RE: **Pitcher Residence**  
**12000 San Antonio NE**  
**Grading Plan Stamp Date: 11/14/19**  
**Hydrology File: E22D007H1**

Based on the submittal received on 11/18/19, the grading plan cannot be approved until the following corrections are made:

GRADING AND DRAINAGE PLAN

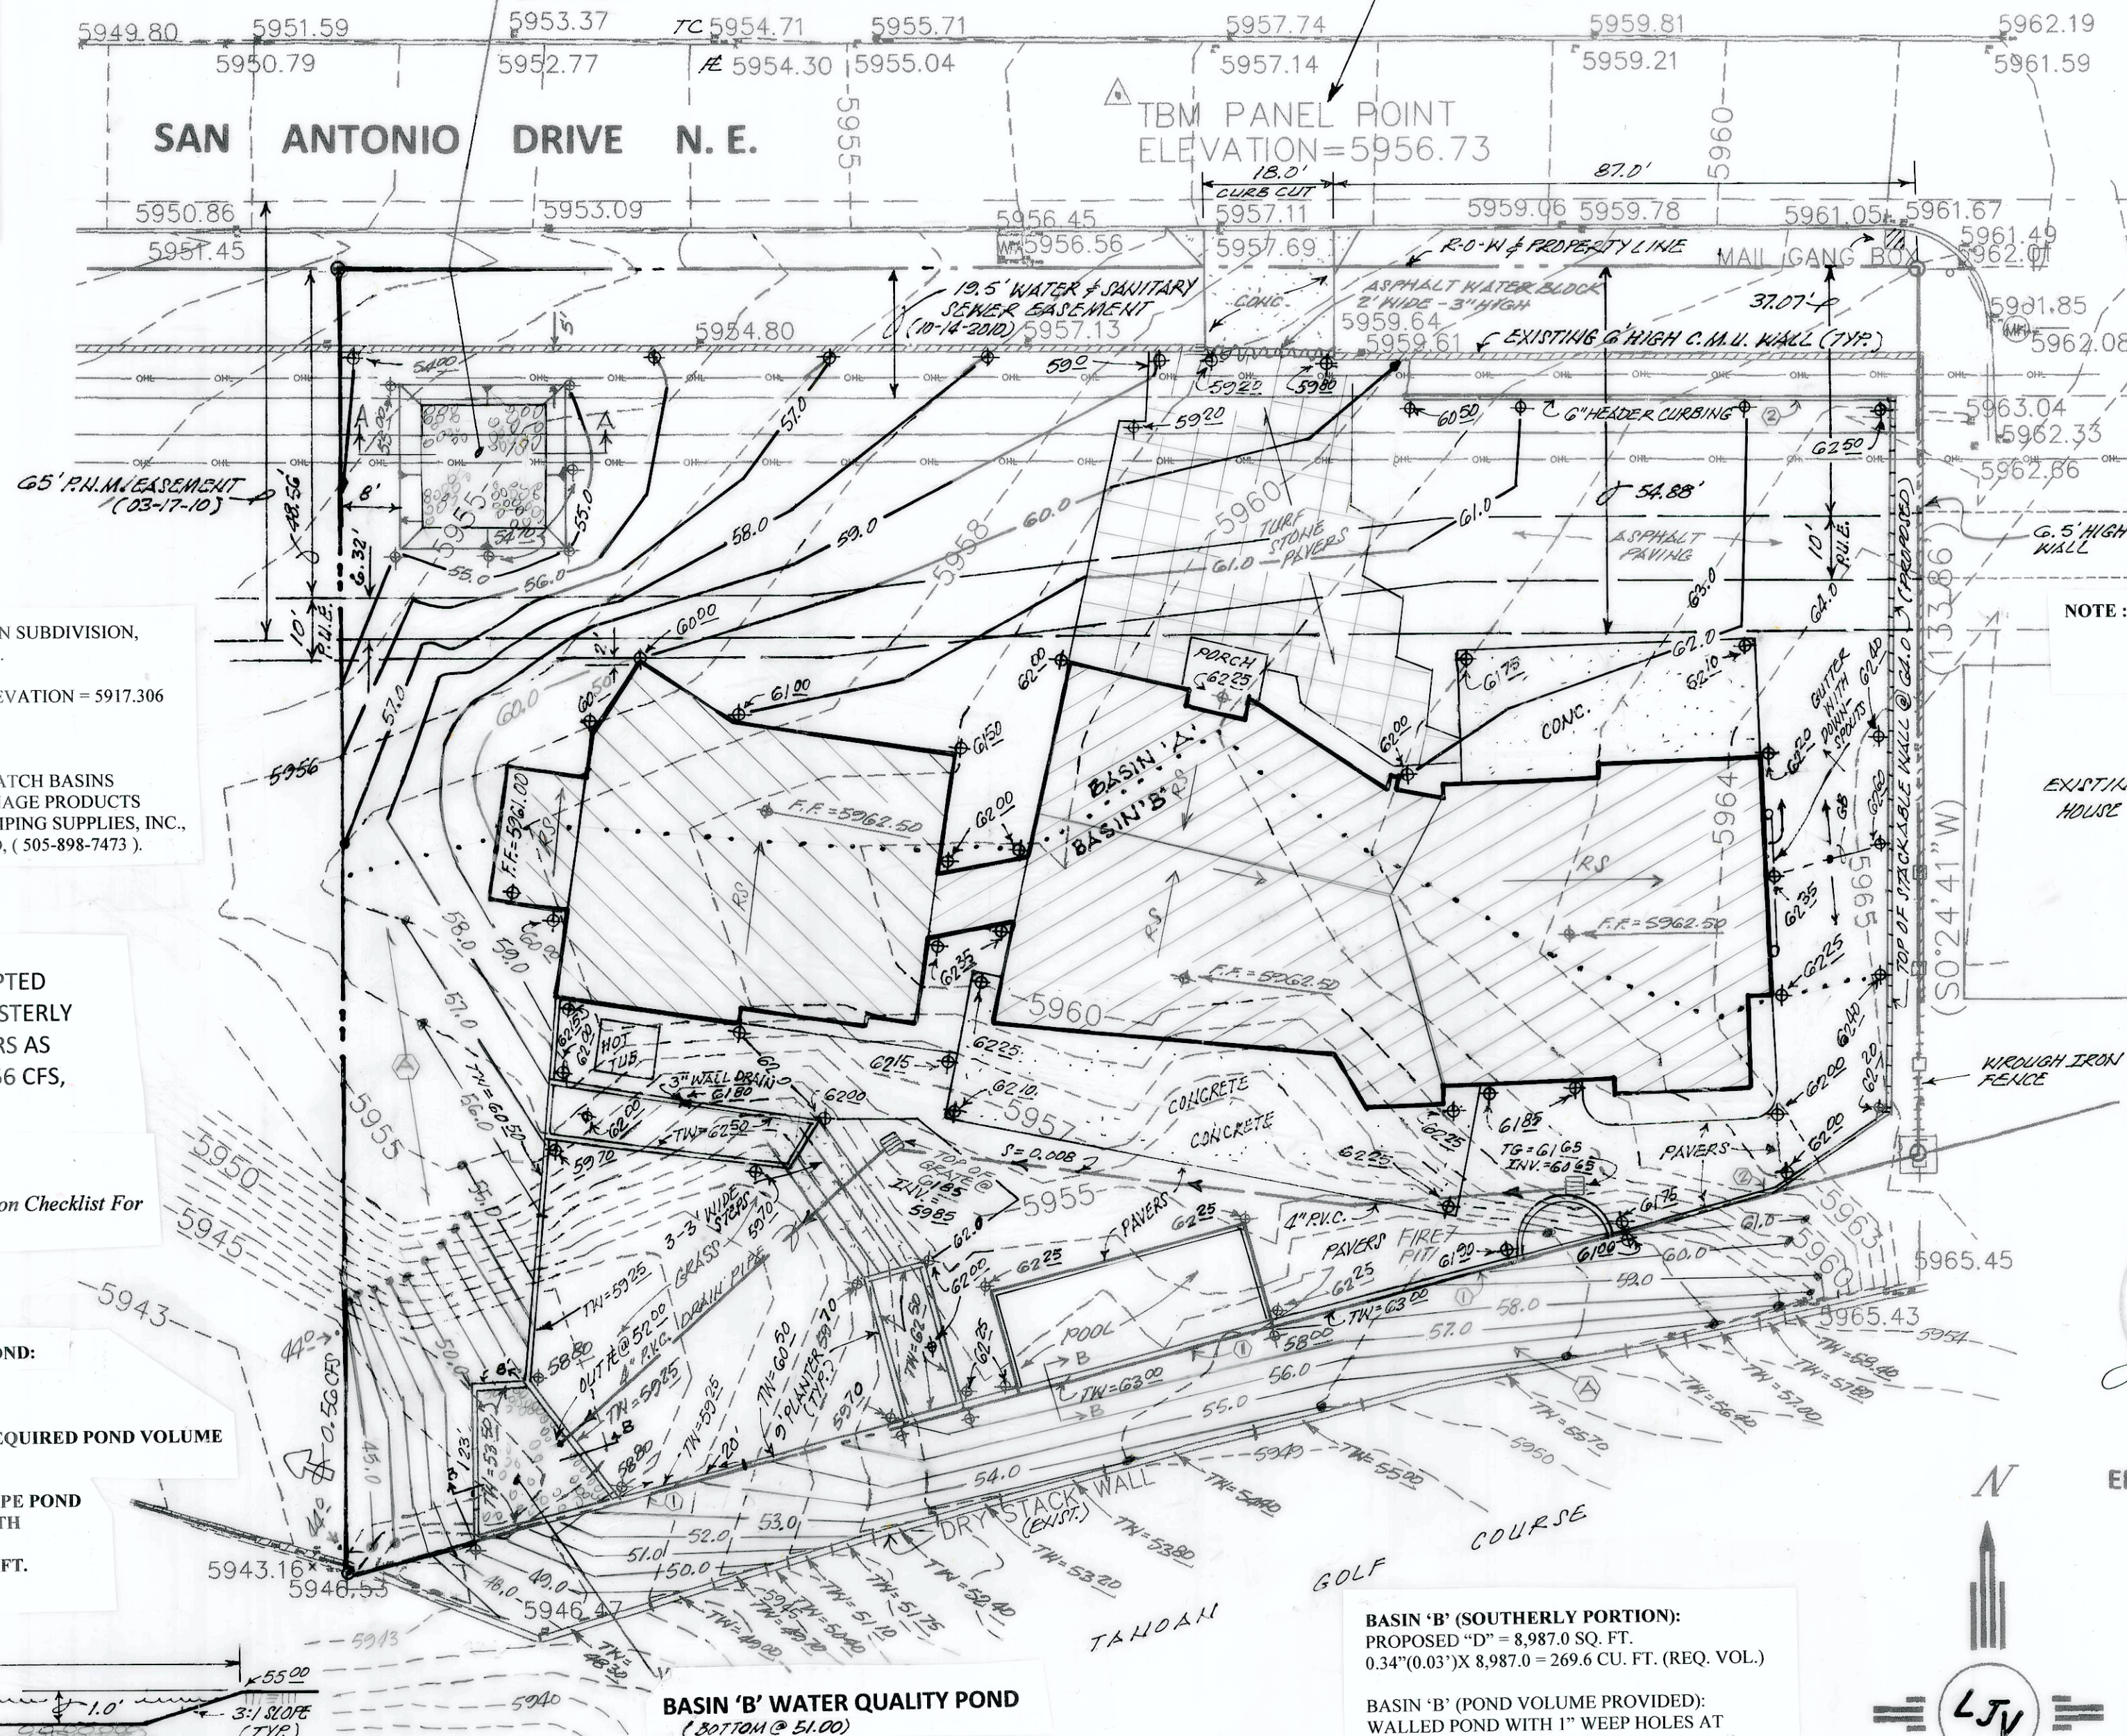
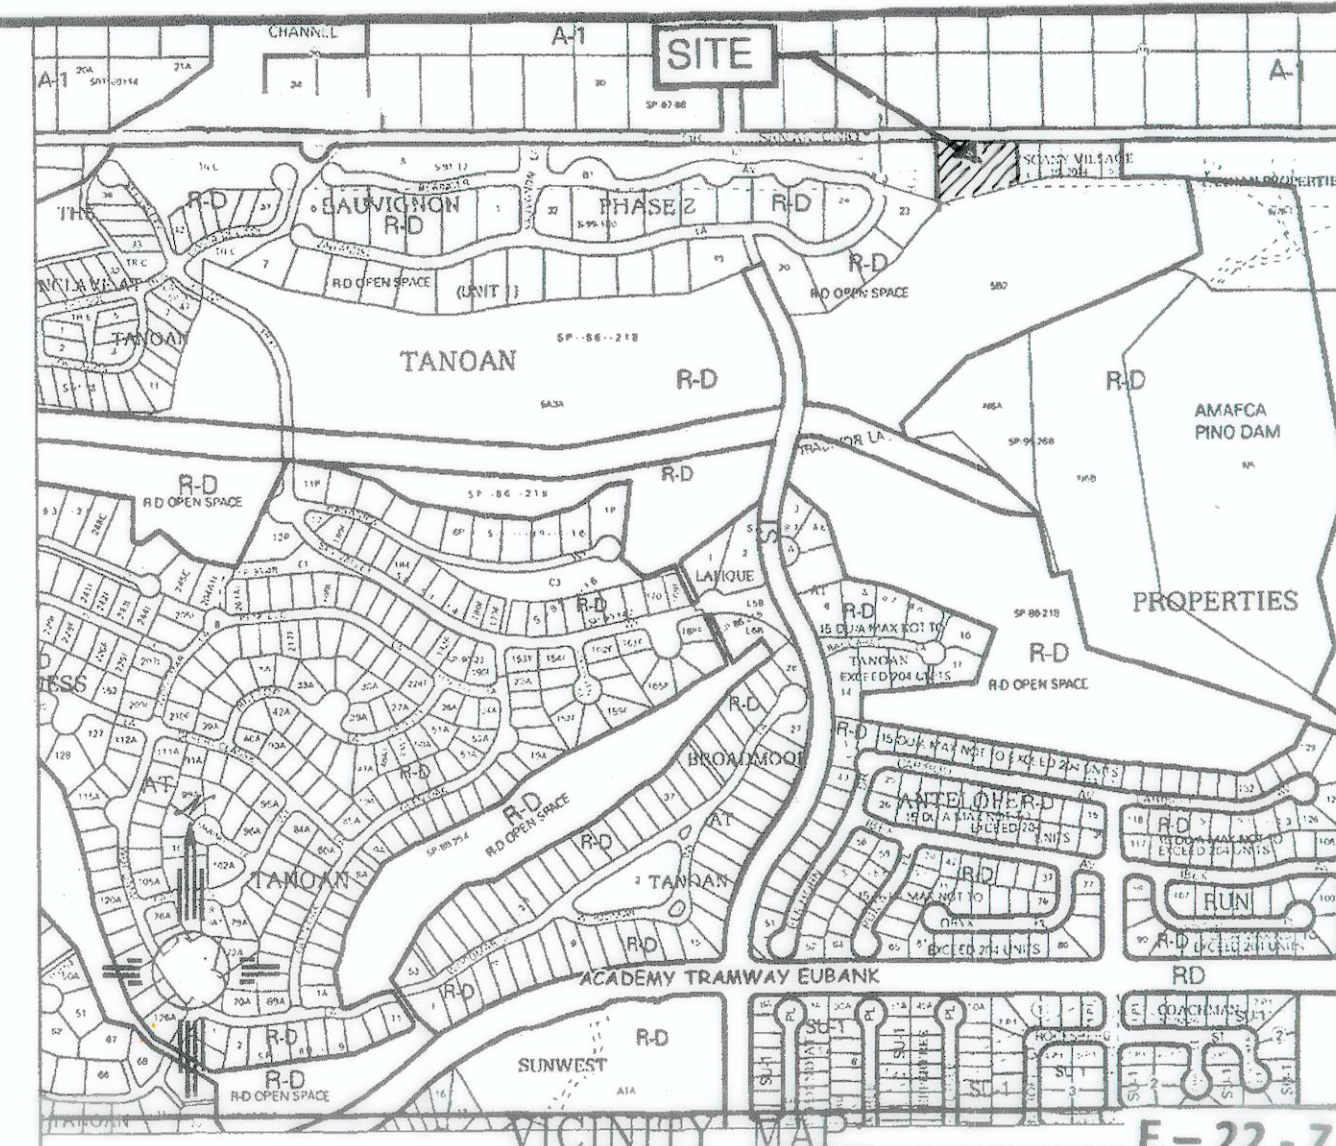
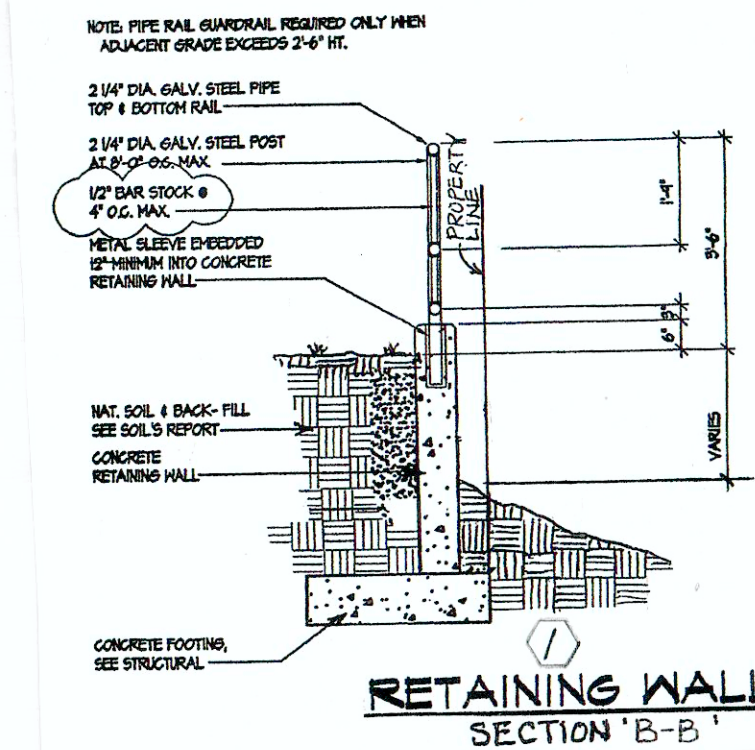
1. Show all easements of record and any utilities.
2. Do not cut the grade or place and buildings in the PUE.
3. Provide written and signed permission from PNM for grading, paving and building construction in their easement.
4. Provide written and signed permission from the property owner to the south to discharge to their property. Per the approved conceptual grading and drainage plan for this site, no discharge to the south was permitted.
5. Along the south property line, why are the spot elevations on the golf course property shown as several feet higher than the contours? If these are proposed elevations, provide written and signed permission from the adjoining property owner for grading their property. If this is new

6. Provide sections through all external boundaries showing proposed retaining walls, garden walls, property/ROW lines, existing and proposed grades. In accordance with DPM Ch.22, section 5 part B, grading and wall construction near the property line may not endanger adjacent property or constrain its use.

7. Proposed grades do not tie-in to existing at the SW corner:

8. Include project datum; all elevation need to be provided in NAVD88.
